BILLINGTON AND LANGHO PARISH COUNCIL
25, Washbrook Close, Barrow, Clitheroë, BB7 9BP.
Tel: - 01254 824782
Email: - tracey@mccarney407.orangehome.co.uk

PLANNING APPLICATIONS

GT **3/2011/0651** – Erection of replacement dwelling at Meadowside, York Lane, Langho

Client MR AND MRS HIGGINS		
Job Title PROPOSED REPLACEMENT DWELLING AT MEADOWSIDE RIBBLE VIEW, YORK		
Drawing Title PROPOSED GROUND AND FIRST FLOOR PLANS INC. SITE LAYOUT.		
Scale 1:100	Date 05/11	Drawn AK

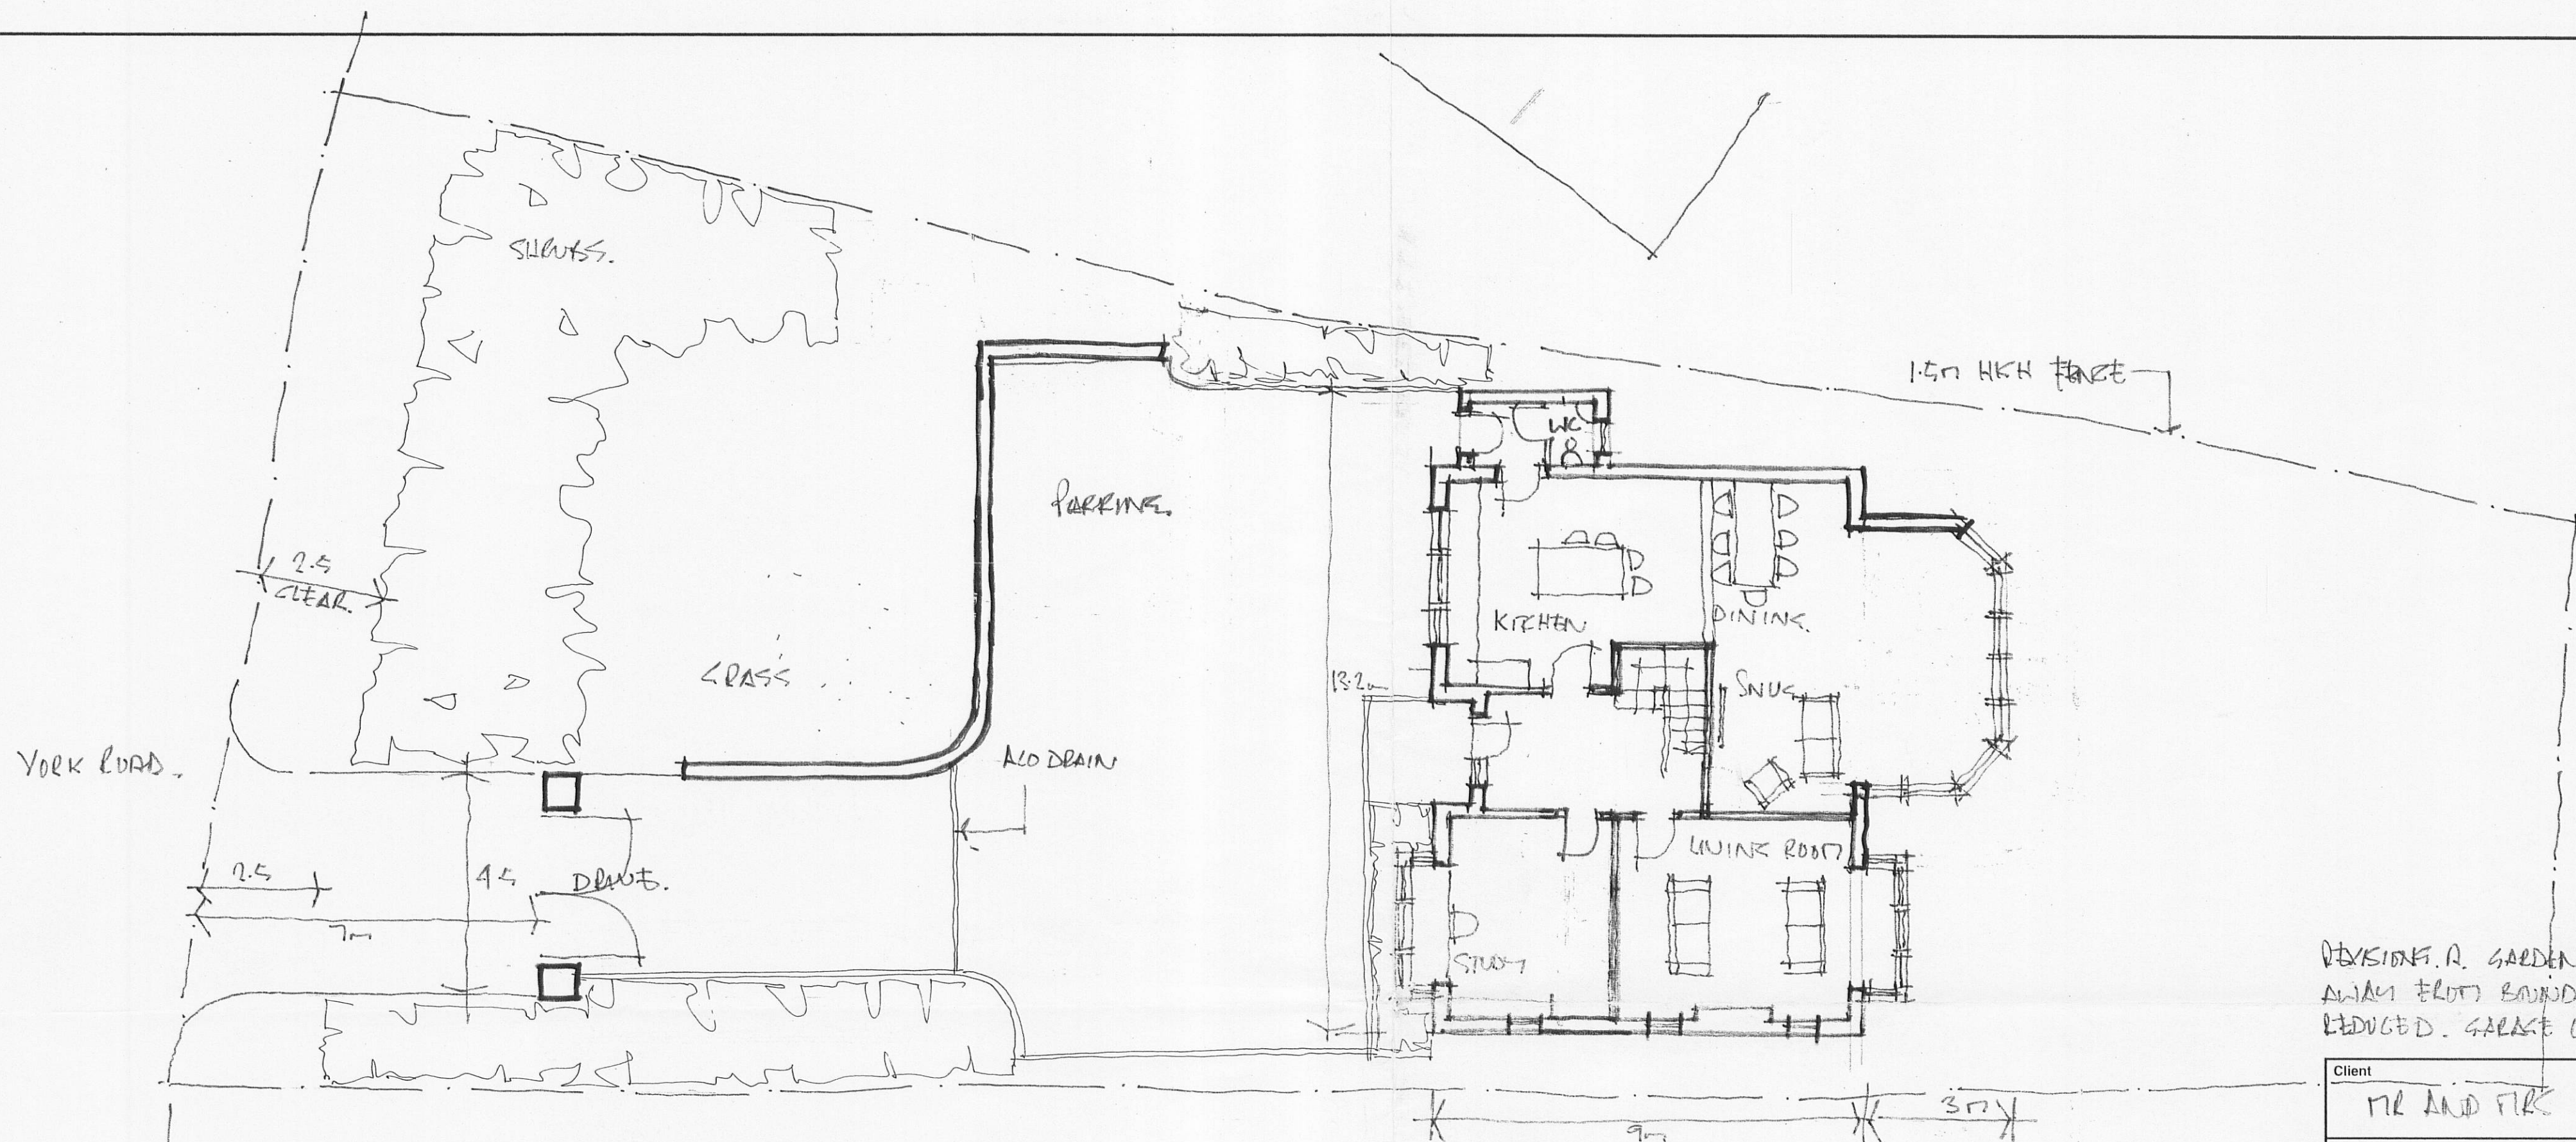
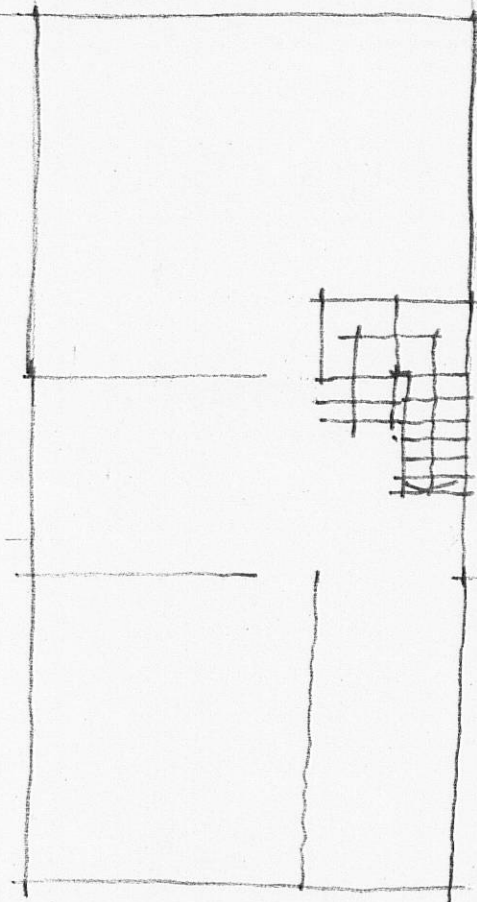
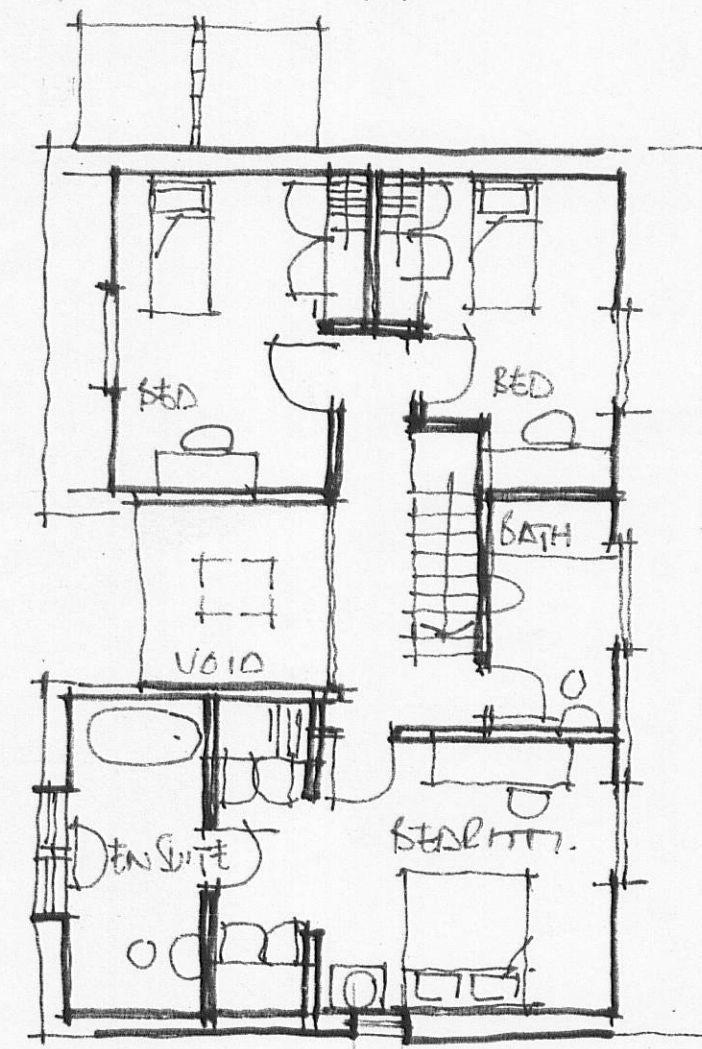
The parish council object to this application as it would be detrimental to the street scene due to its size and design. It would not blend in with the rest of the properties in York Village and the building would be very predominant against the sky line. It contravenes RVBC's policy H14 as the volume of this replacement property will be increased by more than 15%.
